**Application: 2021/62/93644/E**

**Proposal: Erection and operation of grid-connected solar photovoltaic farm, with ancillary infrastructure and landscaping and biodiversity enhancements | Low Farm, Wakefield Road, Flockton, Huddersfield, WF4 4BB**

### **Objection – detrimental impact to ancient woodland**

**Figure 2: Proposed Site Layout (See Document Ref: R002 for scaled drawings)**

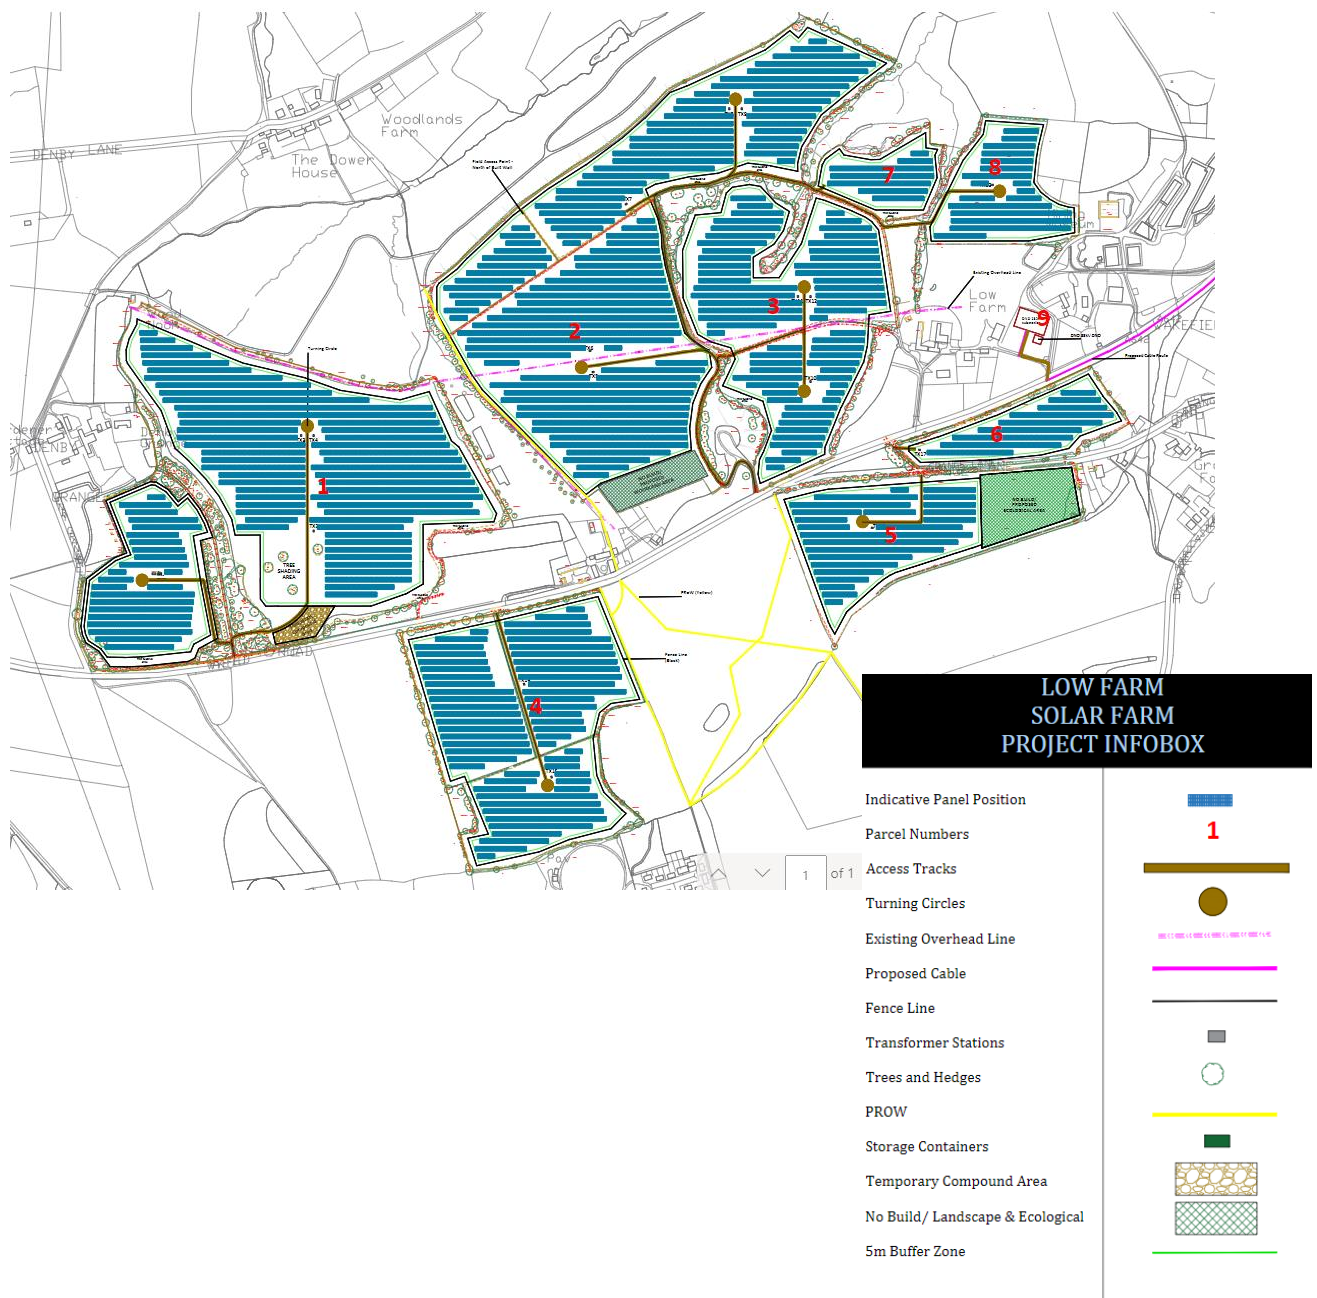
The Woodland Trust is specifically concerned about areas where the wood edge overhangs the solar panels, as boundary trees may become safety issues and be indiscriminately lopped/felled, resulting in a reduction of the woodland canopy and threatening the long-term retention of such trees. In addition, the noise and dust pollution generated from the development - during both construction and operational phases – may result in adverse impact on the adjacent ancient woodland.

We note that the applicants appear to have provided the ancient woodlands with a buffer zone area, however we are unable to determine the size of the buffer zone afforded. Natural England's standing advice recommends the following buffer zones to ancient woodland:

The Trust would like to lodge a **holding objection** to this planning application unless the applicant is able to demonstrate that a 15m buffer in line with Natural England's Standing Advice has been afforded to the two areas of ancient woodland on site.

*"For ancient woodlands, the proposal should have a buffer zone of **at least 15 metres** from the boundary of the woodland to avoid root damage (known as the root protection area). Where assessment shows other impacts are likely to extend beyond this distance, the proposal is likely to need a larger buffer zone. For example, the effect of air pollution from development that results in a significant increase in traffic."*
